CITY OF ALBUQUERQUE

**RE: 4600 Edith Blvd NE – SWMD Admin. Office and Vehicle Maintenance
Conceptual G&D Plan (Engineer's Stamp 4/29/2019)
Hydrology File: G15D202**

Based upon the information provided in your submittal received 5/15/2019, the Conceptual Grading and Drainage Plan can't be approved for Site Plan, Building Permit or Work Order until the following comments are addressed and the plan agrees with the plat and site plan.

CONCEPTUAL GRADING & DRAINAGE PLAN

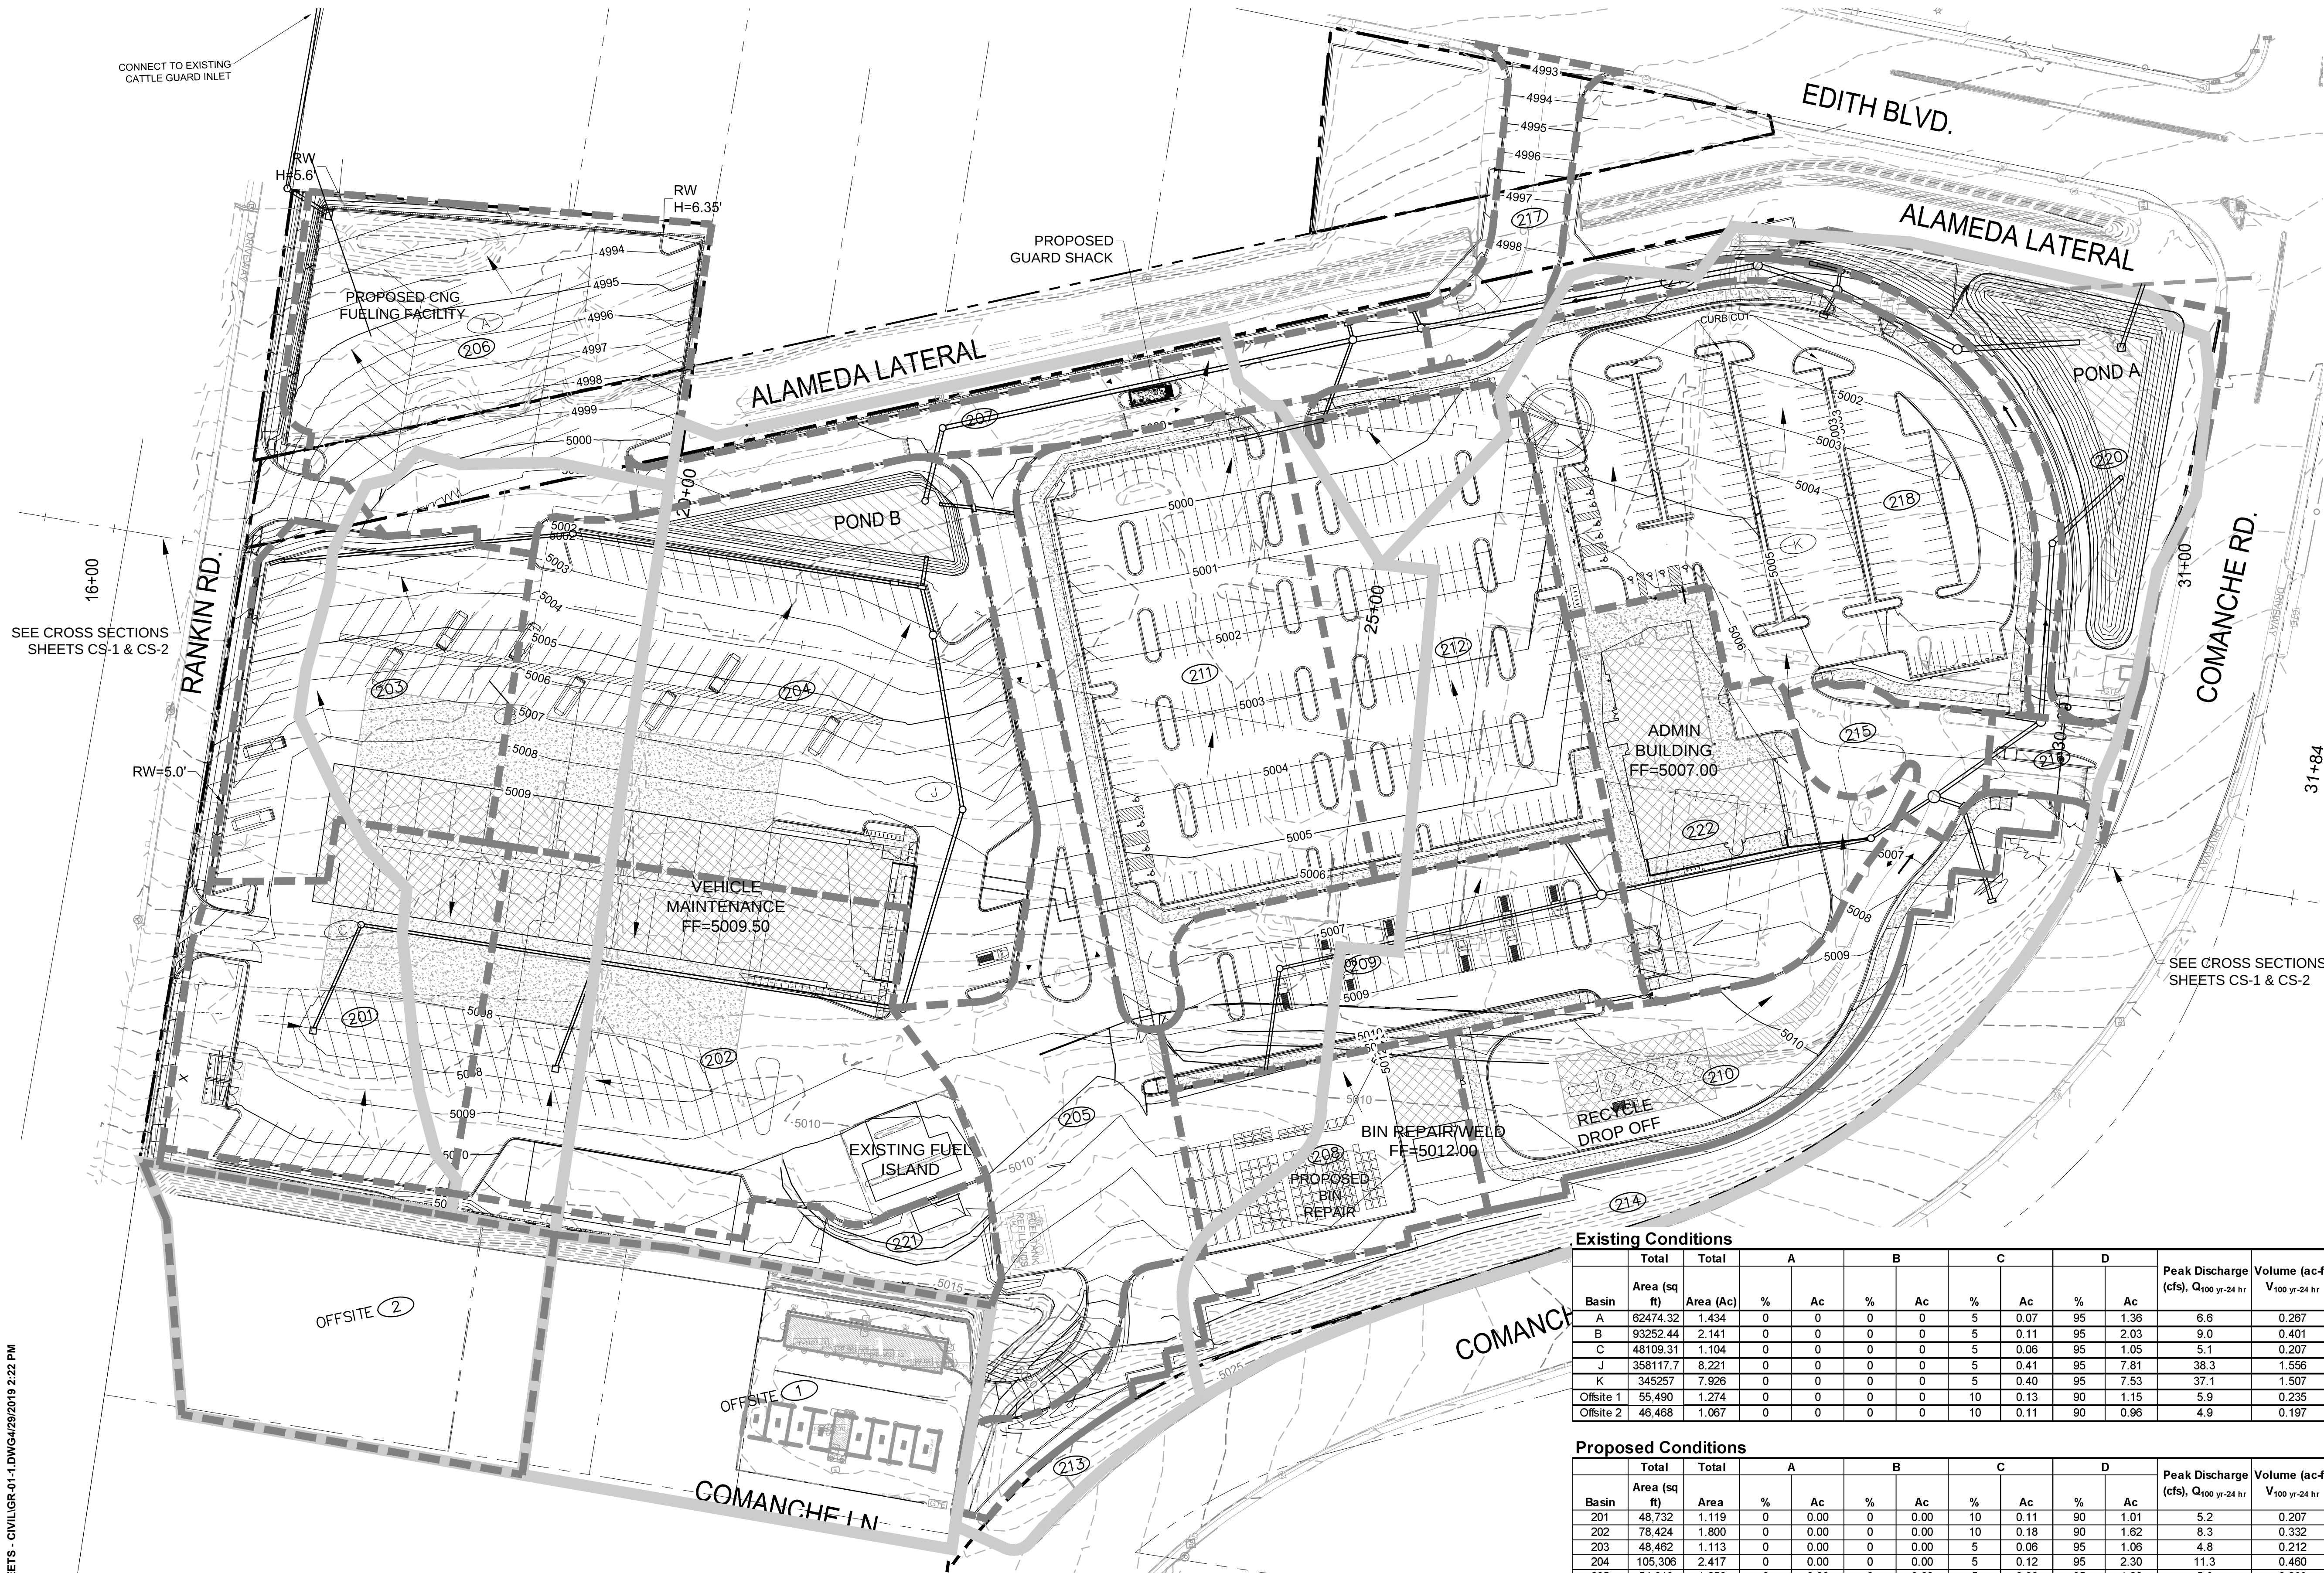
1. Please correct the Stormwater Quality Volume (SWQV) calculation at the end of the "Proposed Conditions" note on sheet GR-1. The required 80th percentile volume is 0.26" excess precipitation from the impervious area.
2. It appears that right of way dedication is needed along Rankin Rd. to contain the new C&G and Sidewalk. Please show the new Right of Way on the G&D Plan.
3. Add an inlet at the west end of the C&G in Rankin Rd. Identify the basin area draining to the new inlet and size the inlet(s) for total interception of the 100 year flows in Rankin Rd.
4. Please add a BMP, Pond C, for Basin 206 below the retaining wall.

5. Remove the label "Not for Construction" from the G&D Plan. Include an overall sheet like the Conceptual G&D Plan and provide a detailed design at a larger scale on multiple 24' x 36" sheets including many more spot elevations and details of the ponds.

7. Please add typical section of Rankin Road to the G&D Plan and include dimensions from the face of curb and sidewalk to the new right of way line. Also provide a typical section of the slope/retaining wall at the west end of the Rankin Rd frontage between the sidewalk and parking lot. The Retaining wall must not encroach into the public right of way.

8. Basin # 206 should be served by a BMP, Pond C, to provide the required SWQV if possible. Please don't place the BMP on the uphill side of the retaining wall. The inlet could be replaced by a rundown into the pond and a pond outlet structure.

9. Please provide construction specifications and details on the G&D Plan for all of the hydraulic structures (build notes). Label the pipes, inlets, and manholes. The numbering system (nodes) in the calculations should be shown legibly on the G&D Plan both the overall plan and the more detailed sheets. The exhibit in the report is not legible.

11. The numbering of Pond A and B on the G&D Plan does not agree with the labels in the AHYMO files, please fix the labels in AHYMO. Pond B, on the G&D Plan, appears to have an extended detention volume of 3' depth which can be counted as the BMP/ SWQV if the pond will drain in 48 hr or more at the average release rate calculated for the average pond depth (1.5'). Please provide separate SWQV calculations for the area draining to each BMP.

13. The hydraulic HGL calculations for the on-site storm drains could not be checked because the pipe and inlet numbers are not shown on a map anywhere. Please add the pipe, inlet and MH labels to the overall G&D Plan and add the EGL to the output data table.

14. Please specify the Curb type/height on the G&D Plan and be sure that the 100 year flow depths do not overtop the curb particularly on the curbs carrying a lot of flow running north and south along the west edge. Especially consider specifying 8" STD C&G in the vicinity of curb opening inlets.
